Planning Officer: Ms Myer

Planning Application Ref: FG/142/21/PL

Location: Land North of Highdown Vineyard (Formerly McIntyre Nursery), Littlehampton Road, Ferring, BN12 6PG

Description of works: Change of Use of the land for the storage of building materials; 2 no. proposed storage containers and 2.4m high Pallisade or Paladin Fencing (coloured green) to perimeter with access gates. This application is a Departure from the Development Plan

Appendix 3: Tree Protection Plan and Recommendations

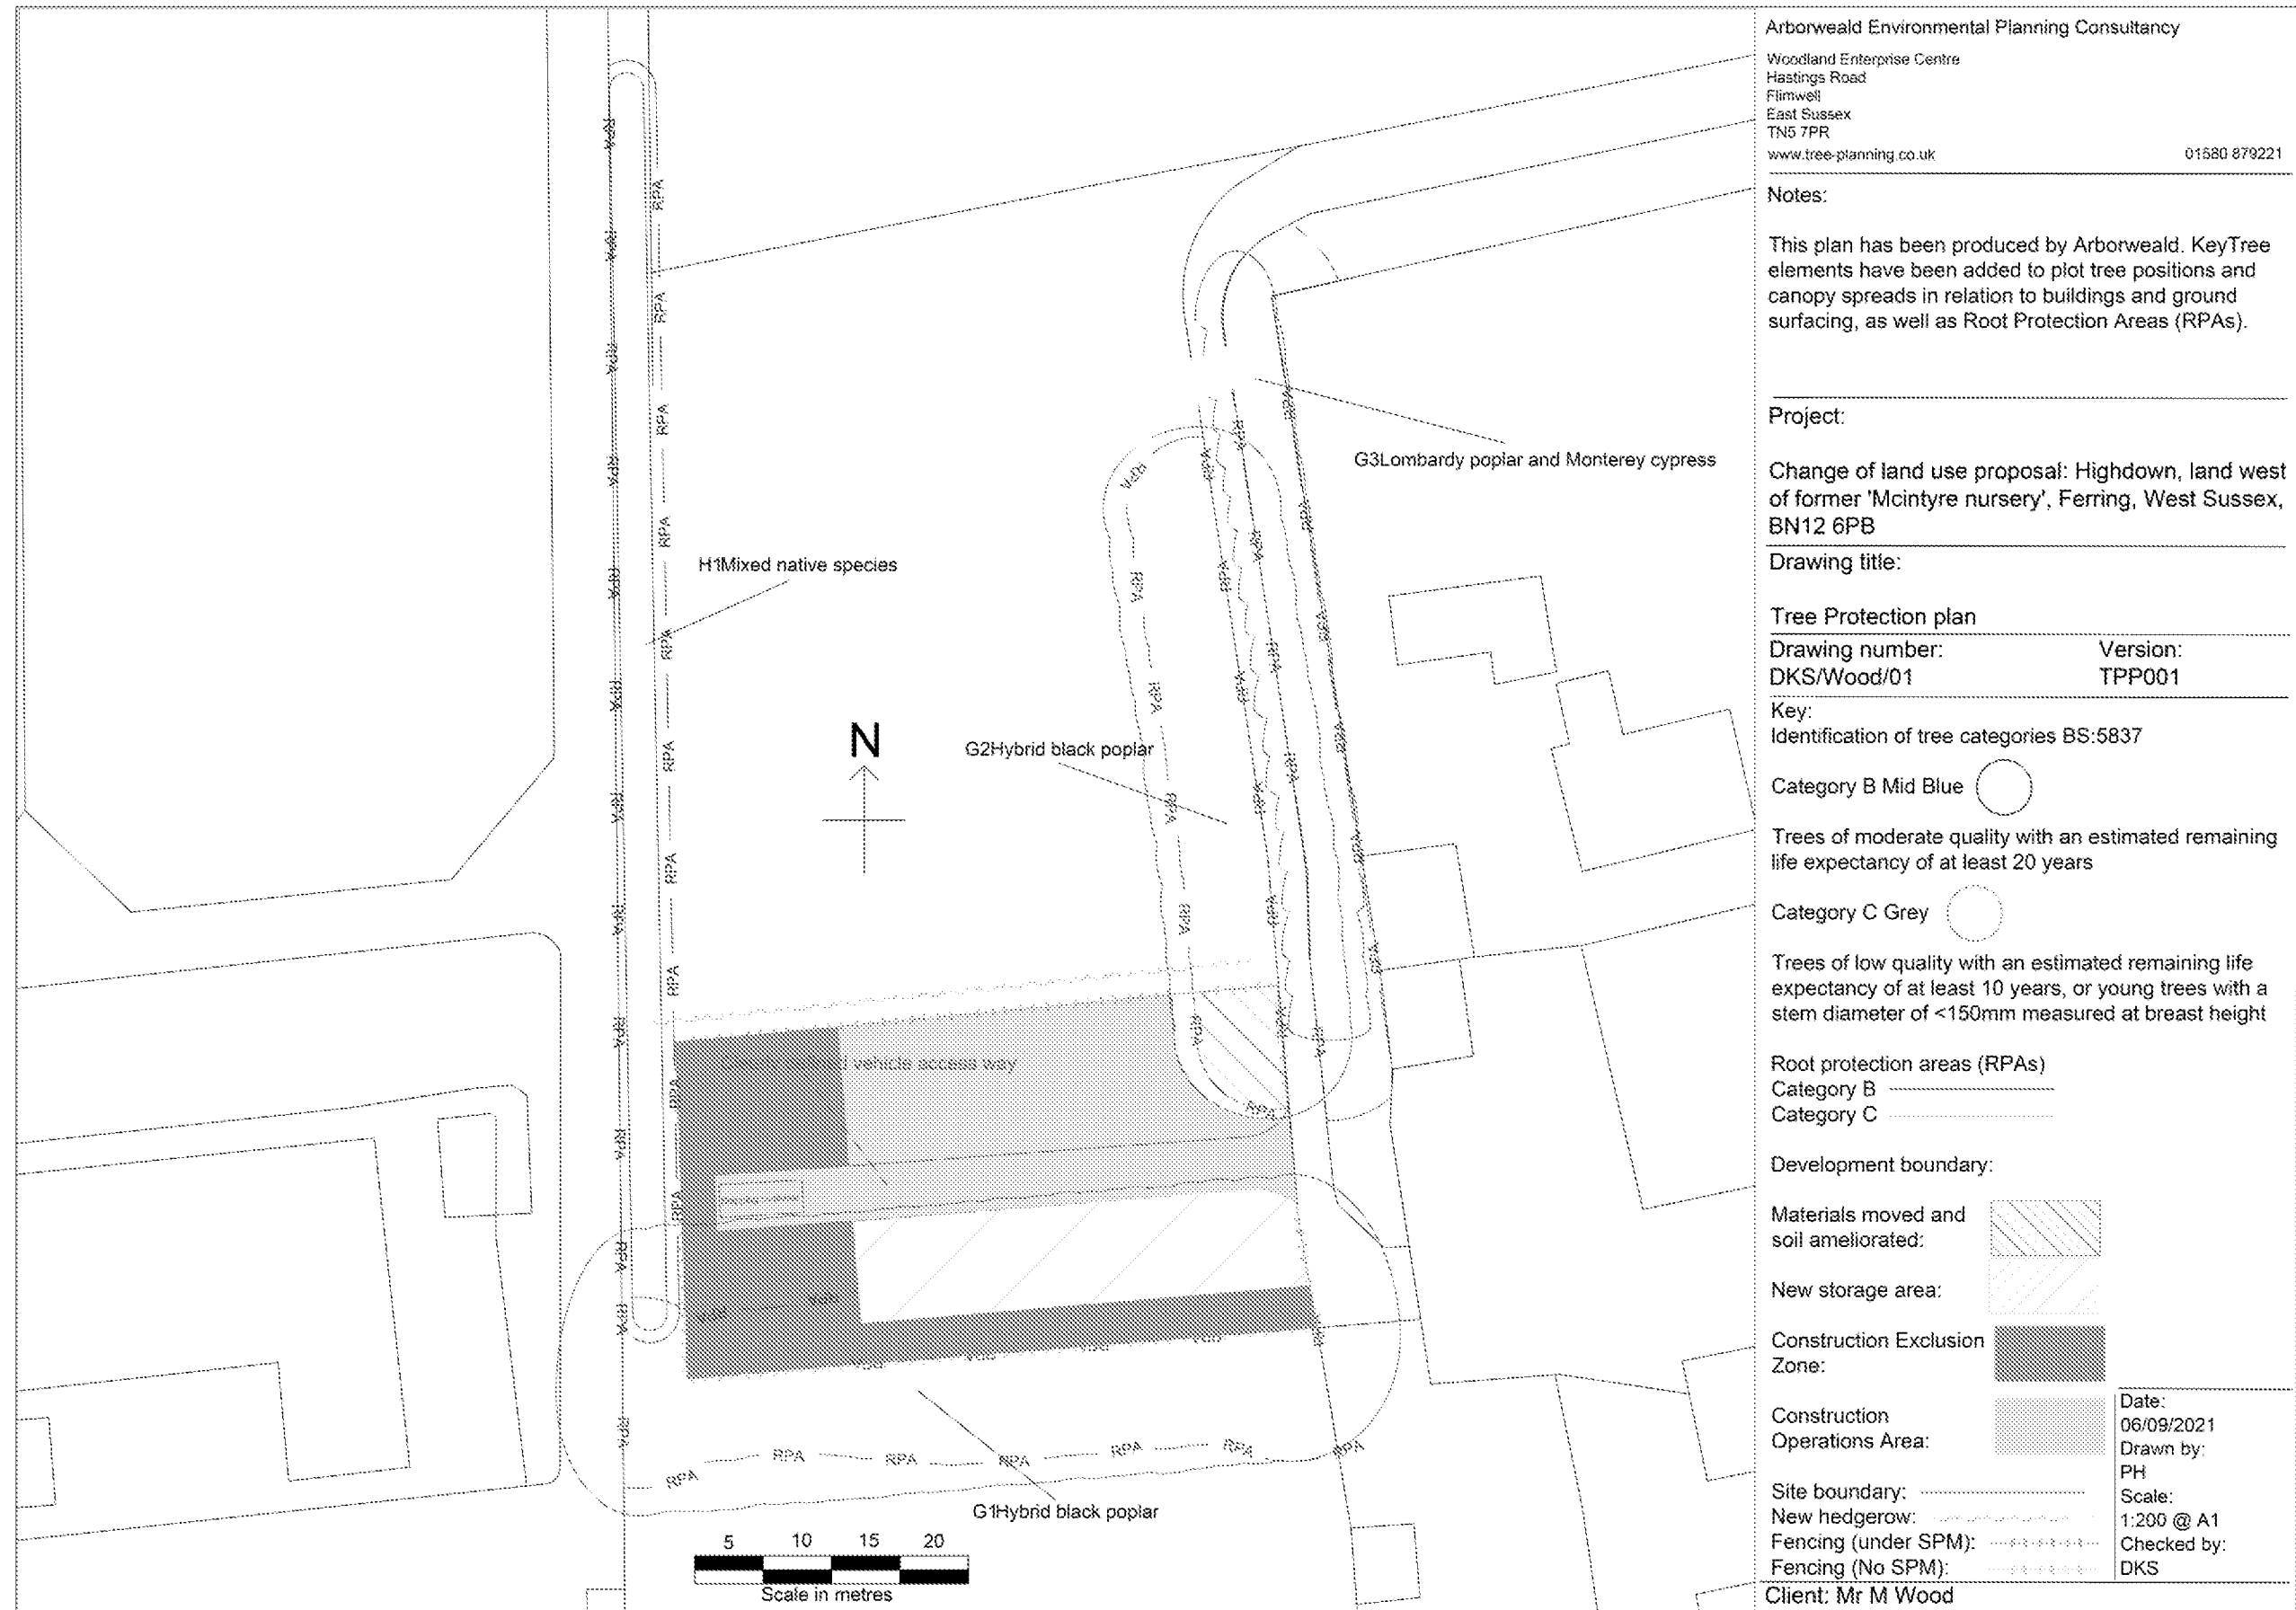
- I recommend the above scheme for **APPROVAL**, subject to the following conditions being applied:
 1. Before the site is occupied or any machinery is introduced to the site or demolition work or construction work or alterations to existing ground levels takes place, written confirmation is required from the Arboricultural Expert representing the site owner(s), confirming that all protective fencing has been inspected and found to be 'Fit for Purpose' as required under British Standard

5837:2012 and been erected and positioned exactly as shown on the **Tree Protection Plan, dwg no. DKS/Wood/01, version: TPP001**

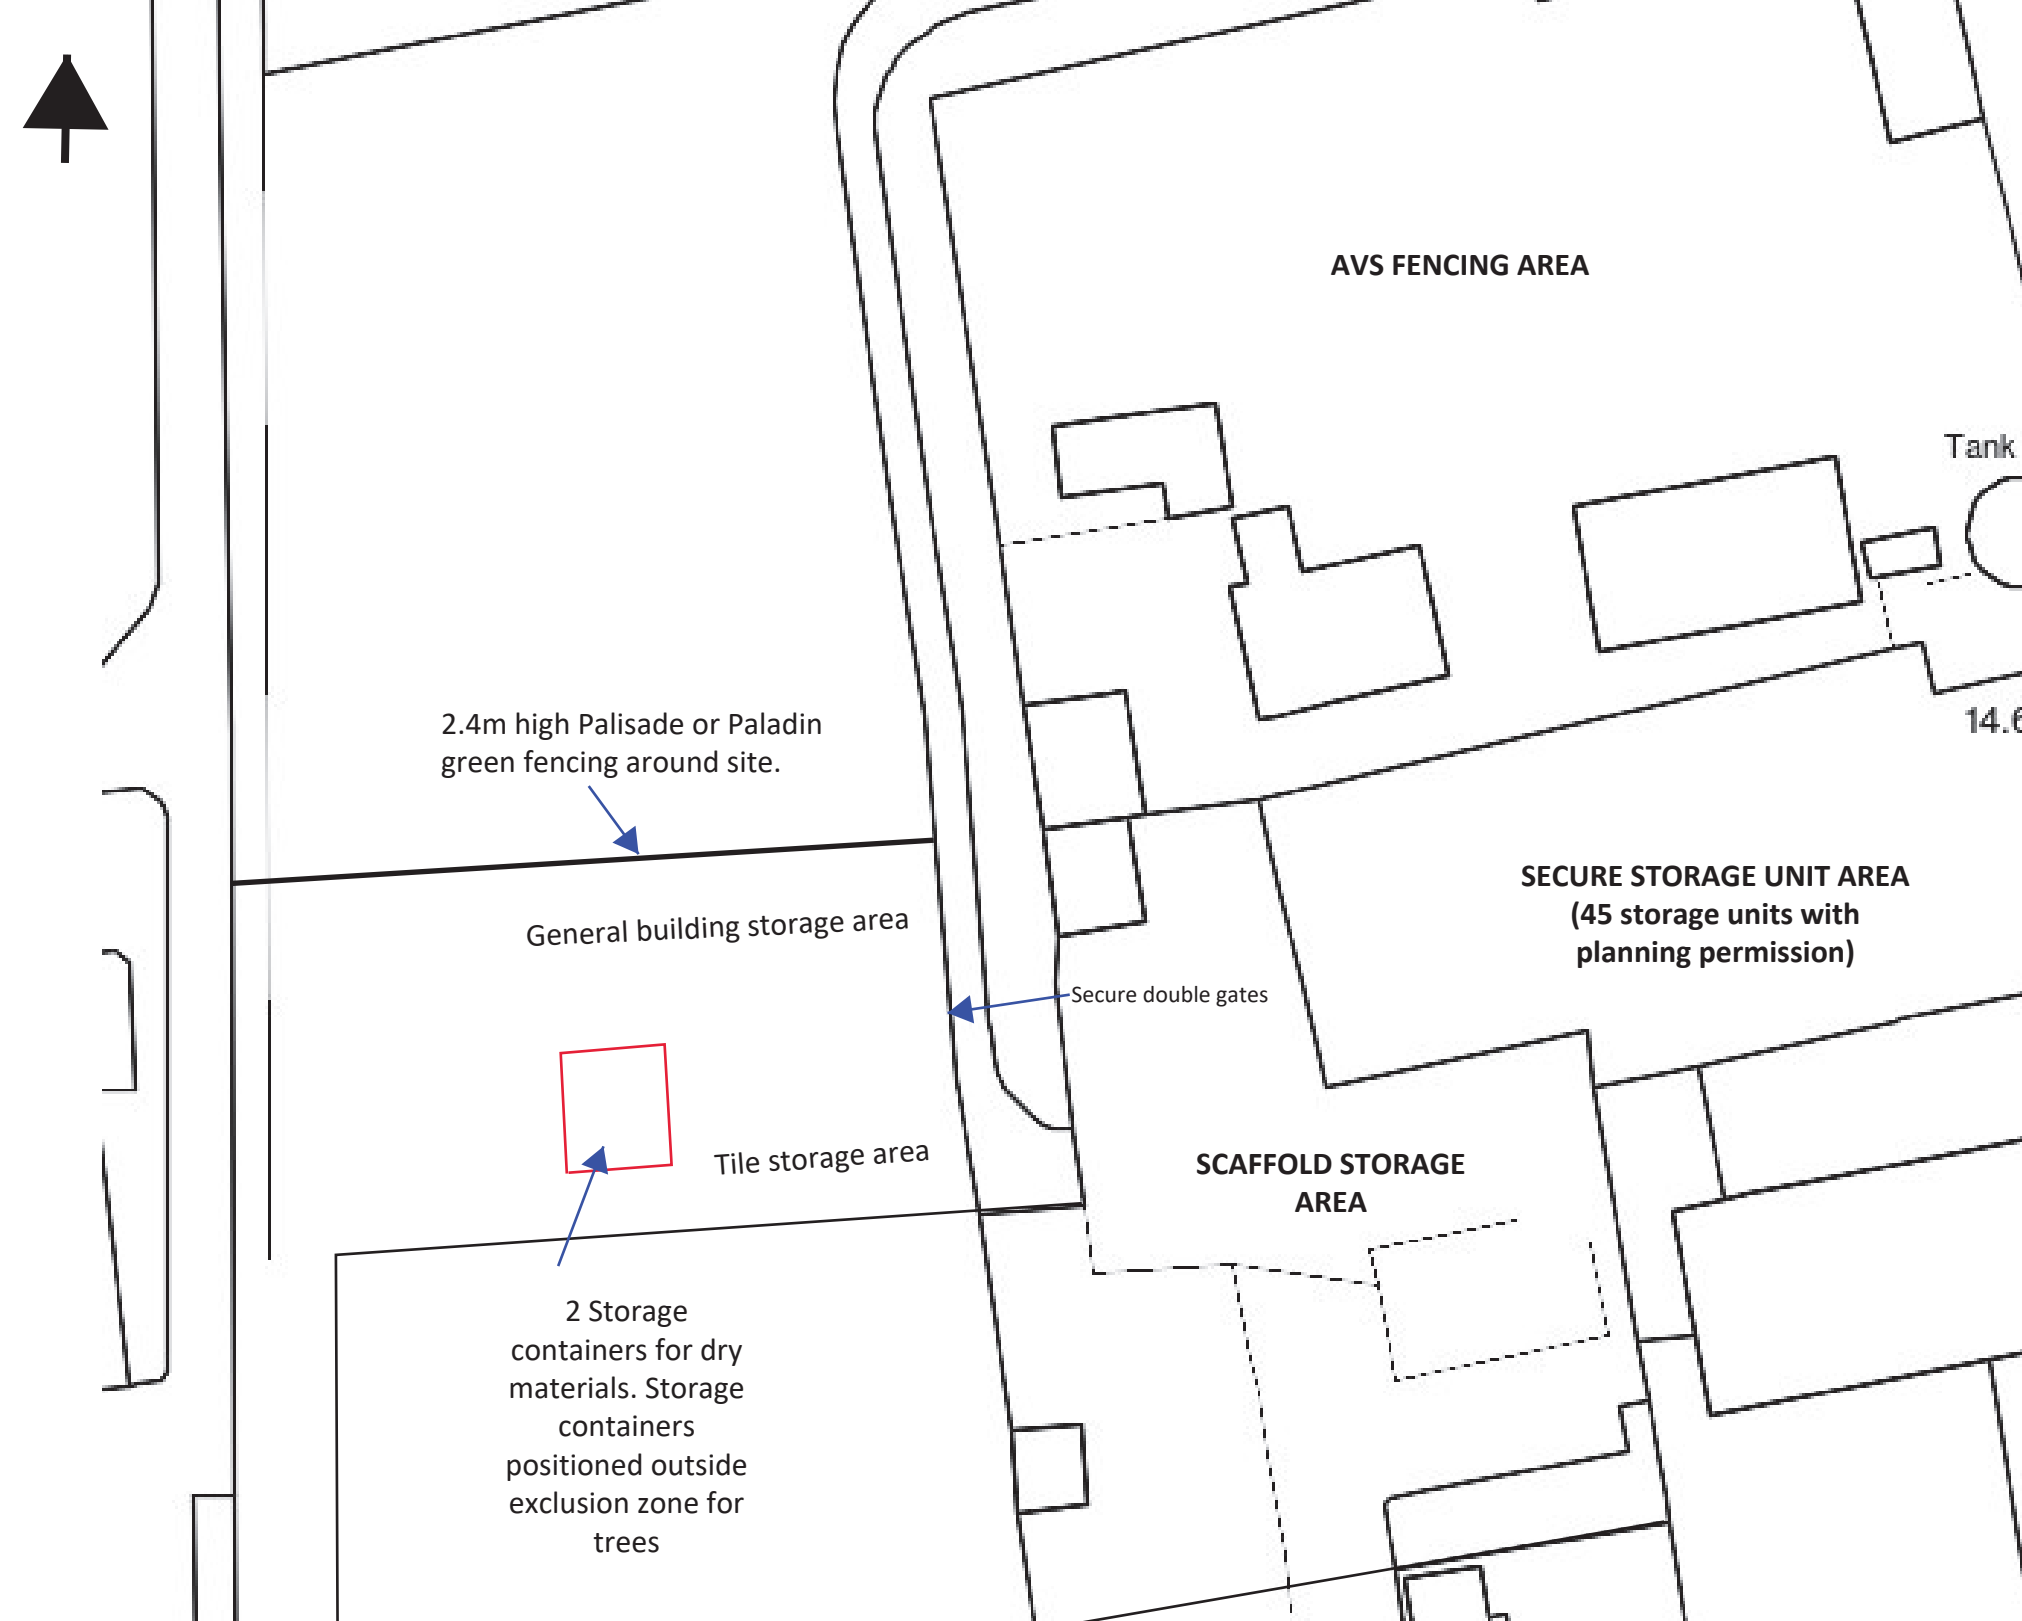
- In respect of soft-landscape proposals (planting alongside the new N boundary fence line), I see there is no detailed landscape plan; that will be required to form part of an appropriately worded condition. I defer to Sue Howell, our Leisure and Landscape Officer on such matters, but a scheme such as described in sect.7.3 and Appendix 5 of the report would seem to be appropriate.
